**KIRKLEES METROPOLITAN COUNCIL
INVESTMENT & REGENERATION SERVICE**

**DELEGATED DECISION TO DETERMINE APPLICATIONS FOR
CONSENT, AGREEMENT OR APPROVAL REQUIRED BY CONDITION**

Reference No:	2023/44/91251/E
Site Address:	adj, 18, Wells Road, Thornhill, Dewsbury, WF12 0LE
Description:	Discharge conditions 6 (parking), 7 (retaining walls/ structures), 8 (wastes), 9 (bat box) 10 (evc), 11 (Phase I Desk Study Report), 17 (drainage) on previous permission 2021/90209 for erection of detached dwelling
Recommending Officer:	Jennifer Booth

DECISION – DISCHARGE OF CONDITIONS – SPLIT DECISION

PHASE	SCALE	SHEET NO.	PROJ.NO.
Building Control	1:50 @ A1 1:100 @ A3	ST-01	E20054

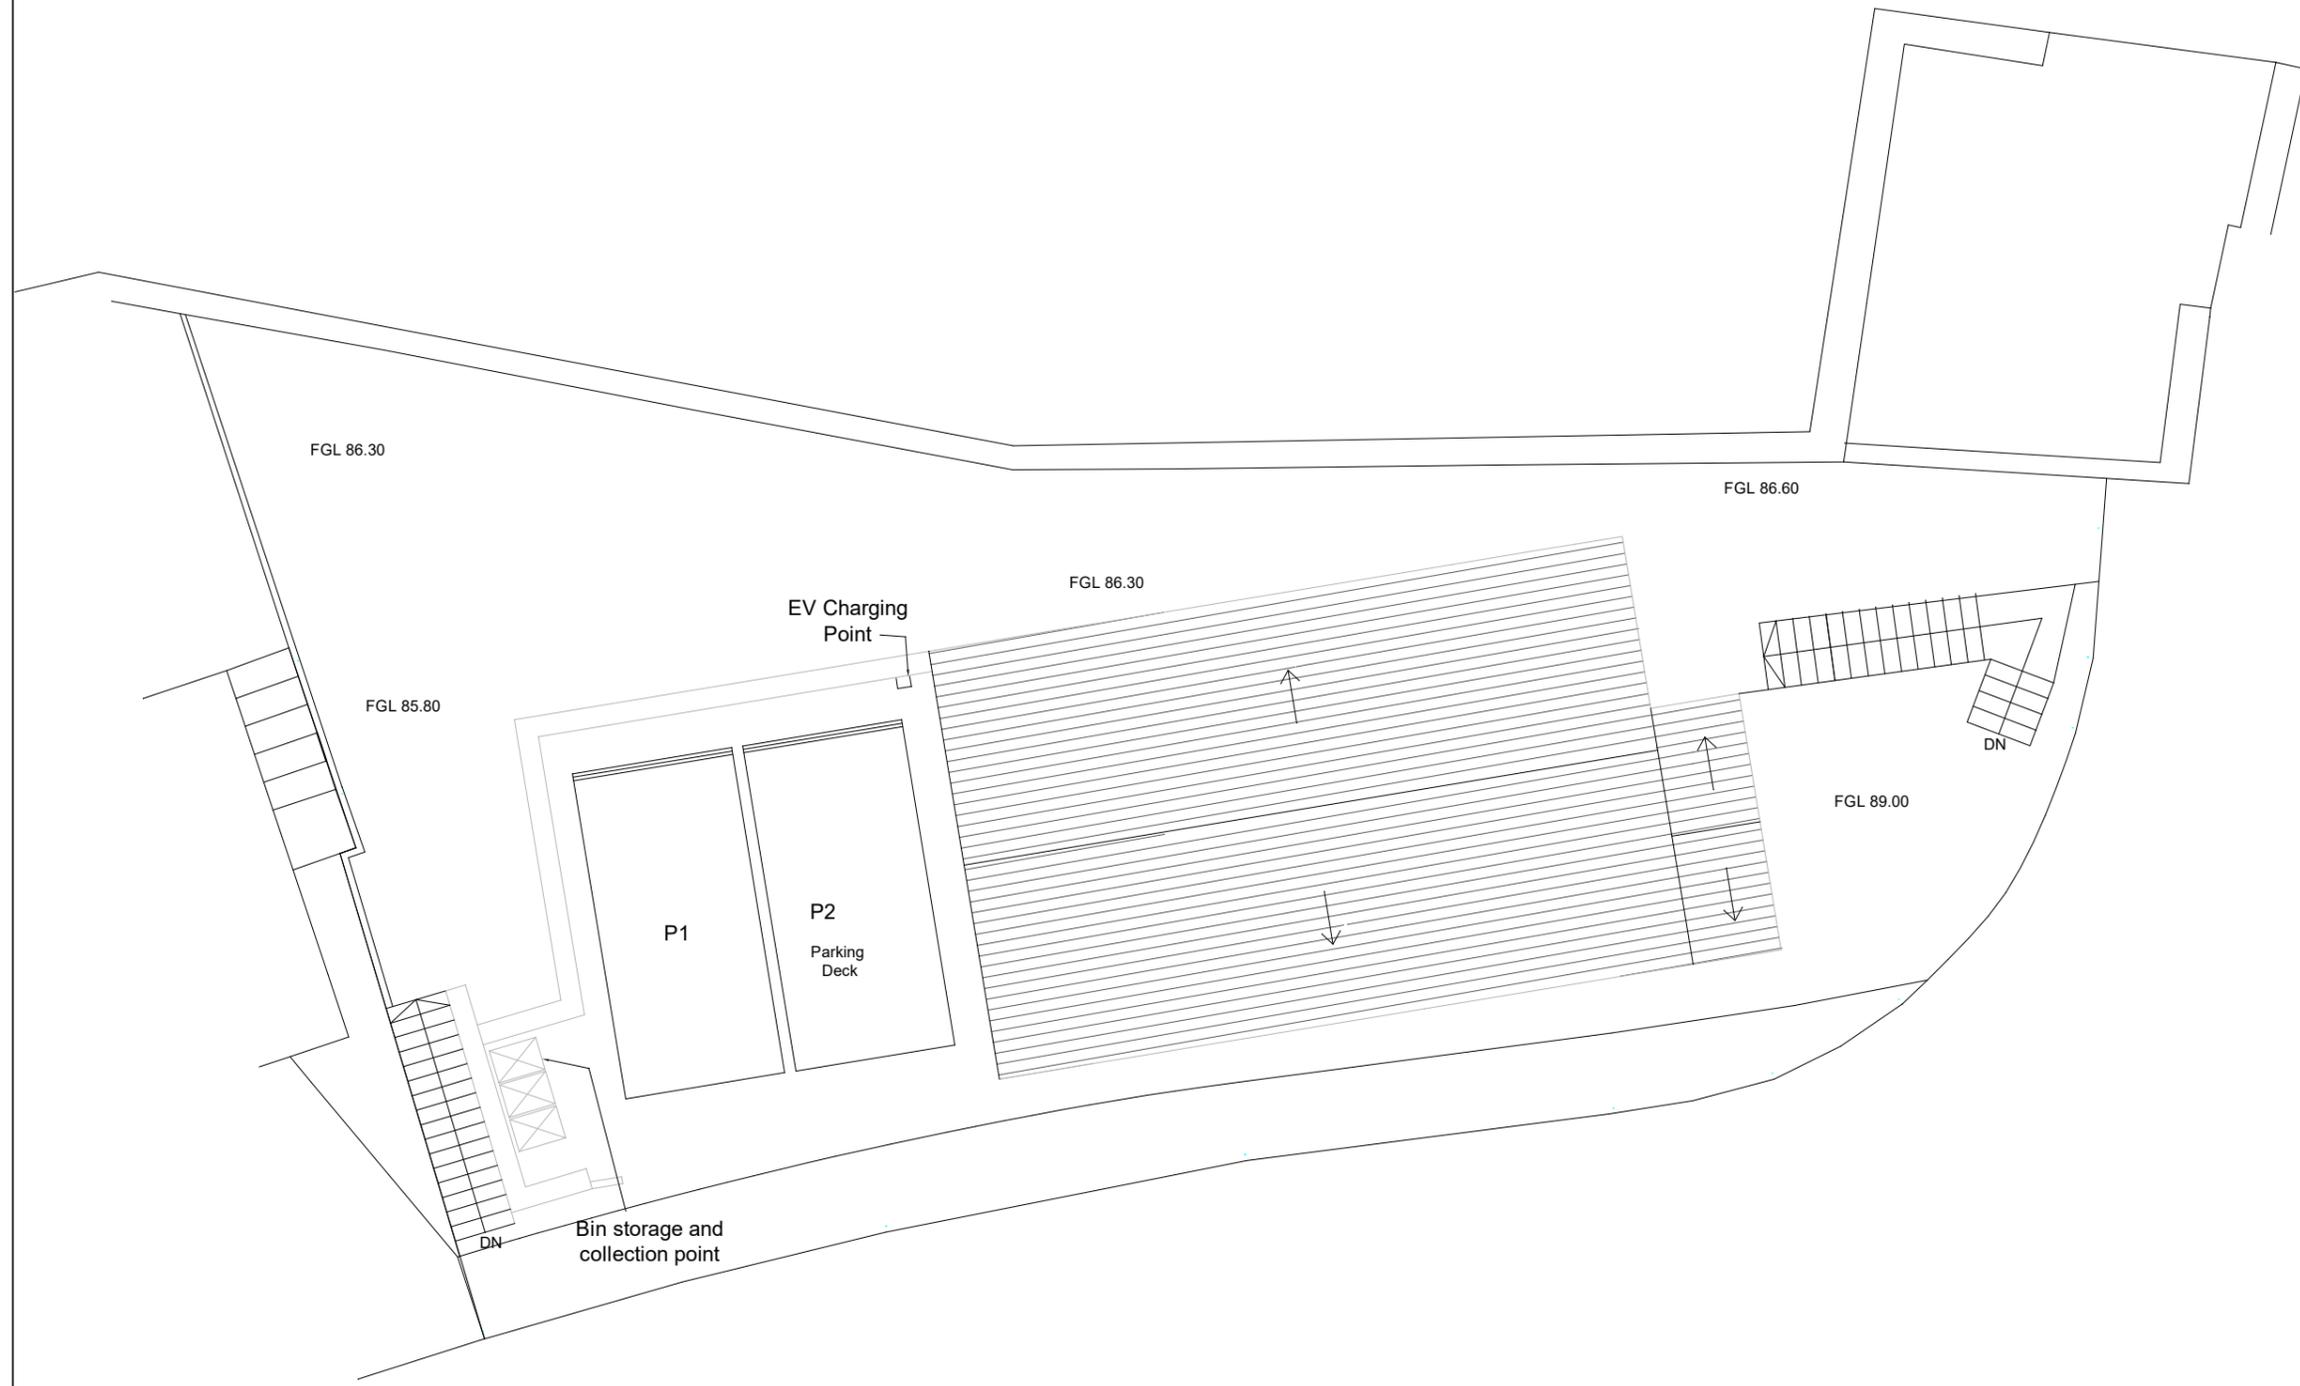
To discharge Condition 10, a site plan ST-01 showing the charging point has been submitted on 26/04/2023. This information was assessed by the K.C.

Environmental Health Team and they confirm that providing the development is completed with the EVC point, the condition would then be considered to be discharged.

Condition 10 regarding the provision of EVC charging can only be considered to have been discharged when the development is completed with the EVC charge point in situ and retained thereafter.

PHASE	SCALE	SHEET NO.	PROJ.NO.
Building Control	1:200 @ A3	ST-10	E20054

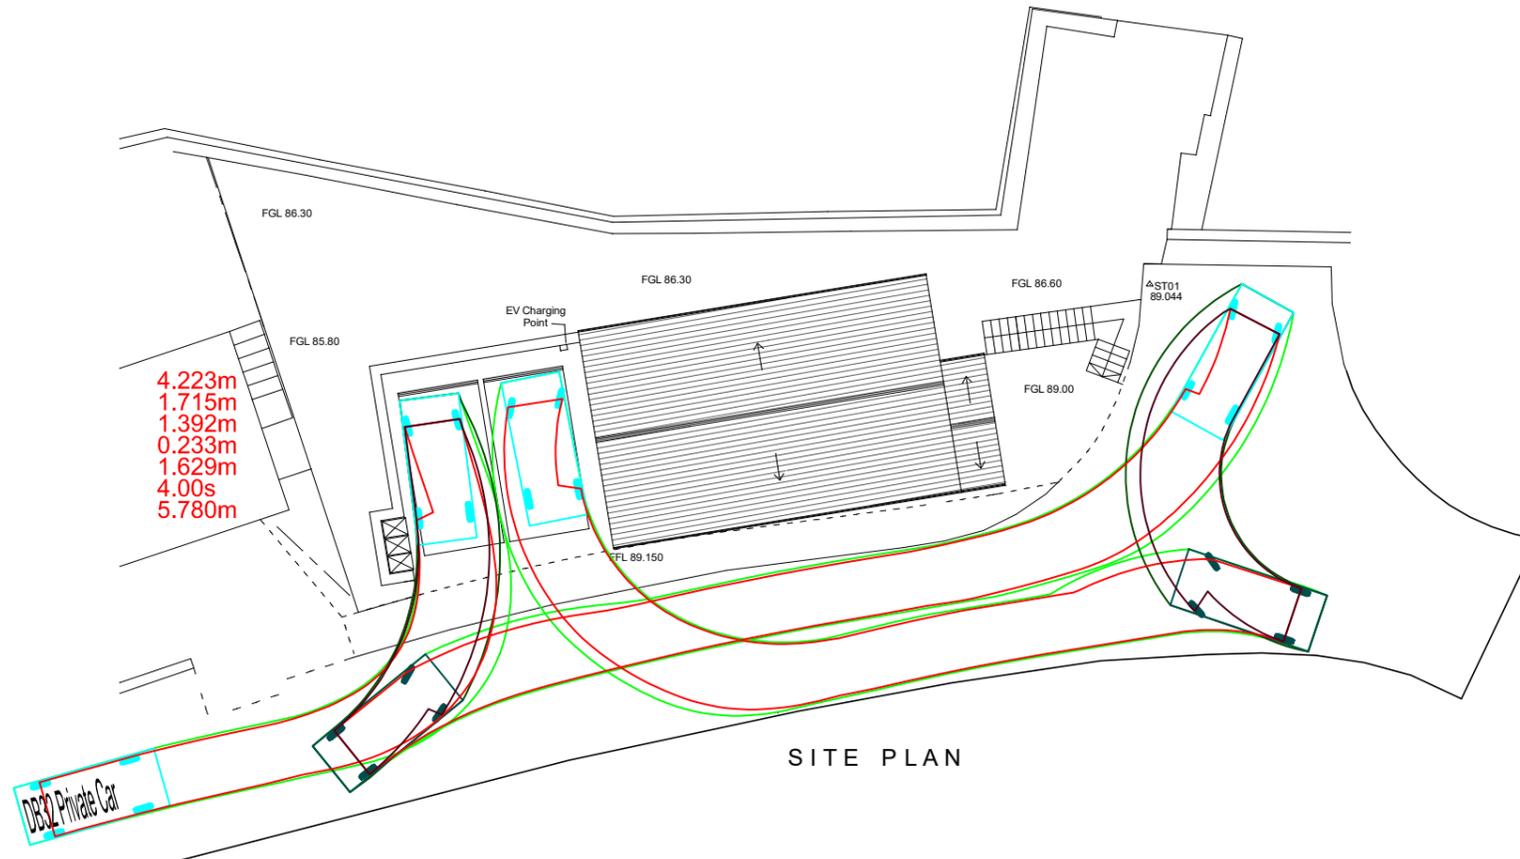
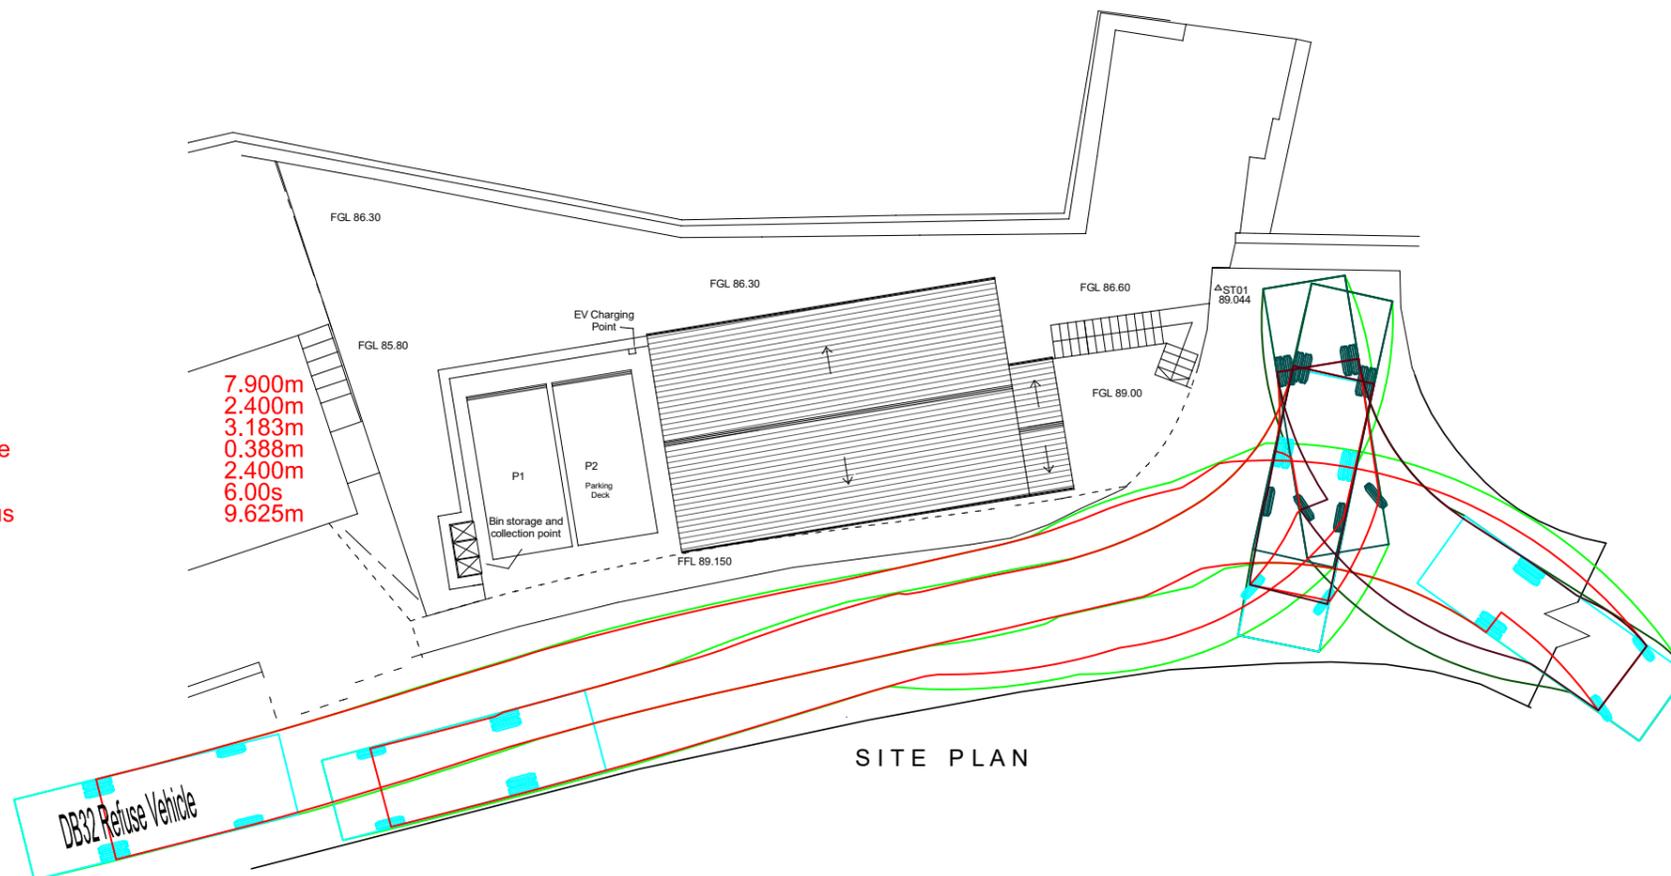
To discharge Condition 6, a vehicle tracking plan – ref ST13 showing the provision of two parking spaces, P1 and P2, has been submitted on 26/04/2023. This information has been assessed by the K.C. Highways DM team and as it is lacking a TRO or adequate information to enable full consideration. This condition cannot therefore be considered to be discharged at this time.

To discharge Condition 8, a vehicle tracking plan – ST13 showing the path of the refuse vehicle has been submitted on 26/04/2023. This information was assessed by the K.C. Highways DM team and is considered to be acceptable to discharge the condition.

There is insufficient information and the appropriate additional submissions have not been made to Highways with regards to conditions 6 (parking – the provision of an agreed TRO) or 7 (retaining walls/structures – the provision of an agreed AIP),

PHASE	SCALE	SHEET NO.	PROJ.NO.
Planning	varies @ A3	ST-13	E20054

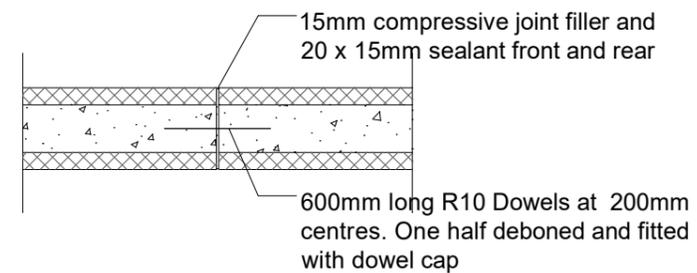
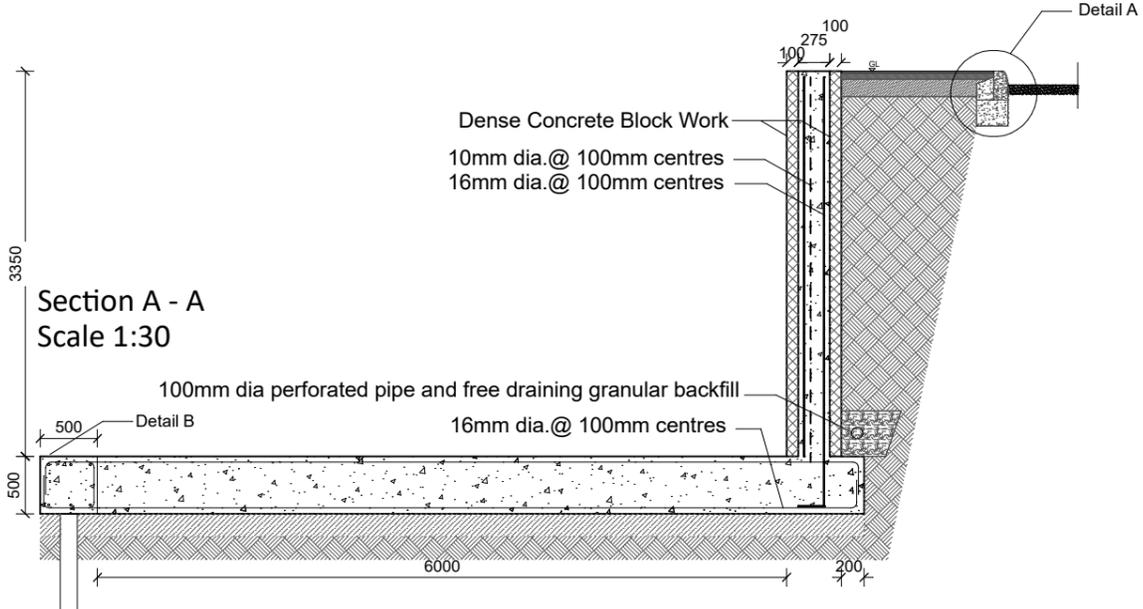
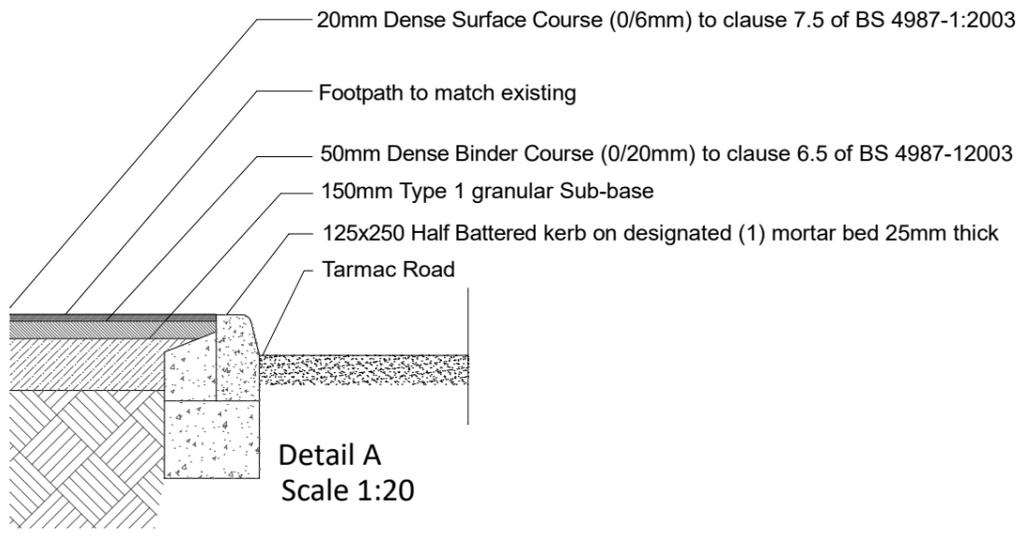
To discharge Condition 7, a retaining wall plan – ST10 has been submitted on 26/04/2023. This information was assessed by the K.C. Highways DM team and is lacking as technical approval is required via the submission of an AIP. This condition cannot therefore be considered to be discharged.
